MECKLENBURG COUNTY
Land Use & Environmental Services Agency

MEMORANDUM

To: Charlotte-Mecklenburg Planning Commission
From: LUESA, Mecklenburg County
Date: 7.27.23
Subject: Rezoning Petition Comments

2023-033: Centrum Elizabeth Mixed use

SHEET NUMBER **RZ1-00**

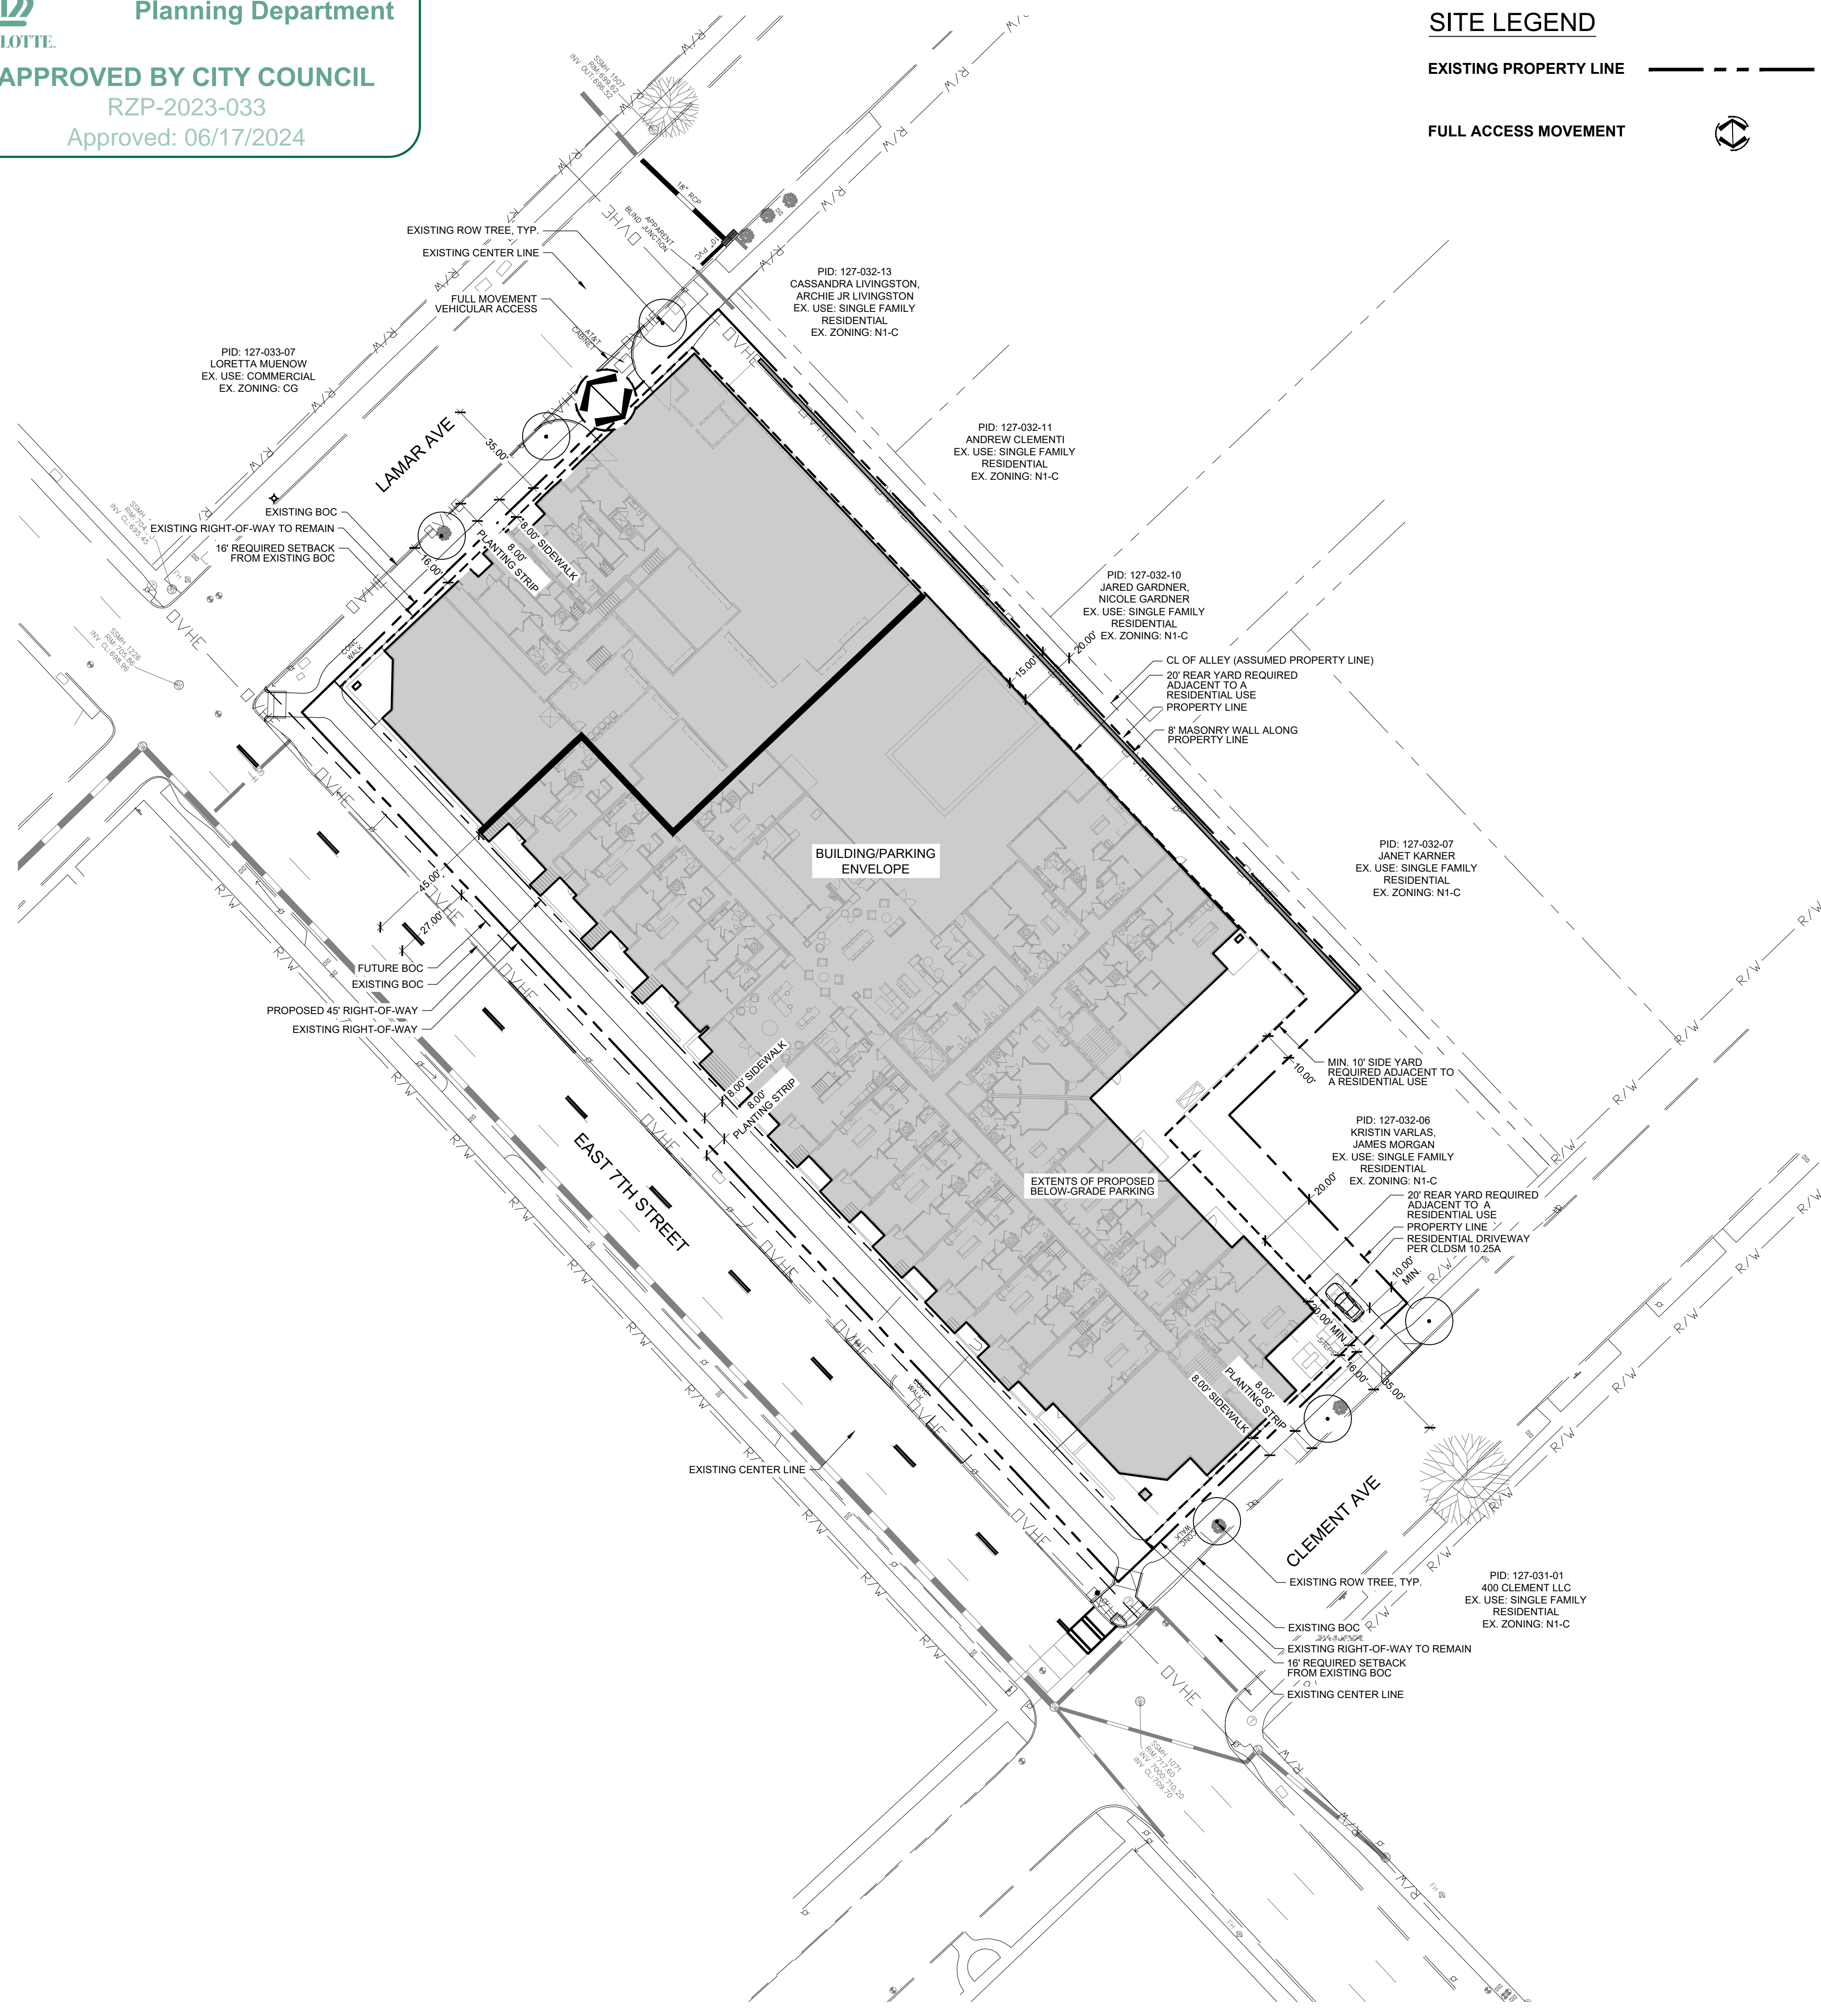
Groundwater & Wastewater Services records indicate a Subsurface Investigation Permit (SIP) was issued for parcel 127-032-05. Please note that monitoring wells on this parcel need to be located, flagged and protected prior to development or be permanently abandoned in accordance with the Mecklenburg County Groundwater Well Regulations.
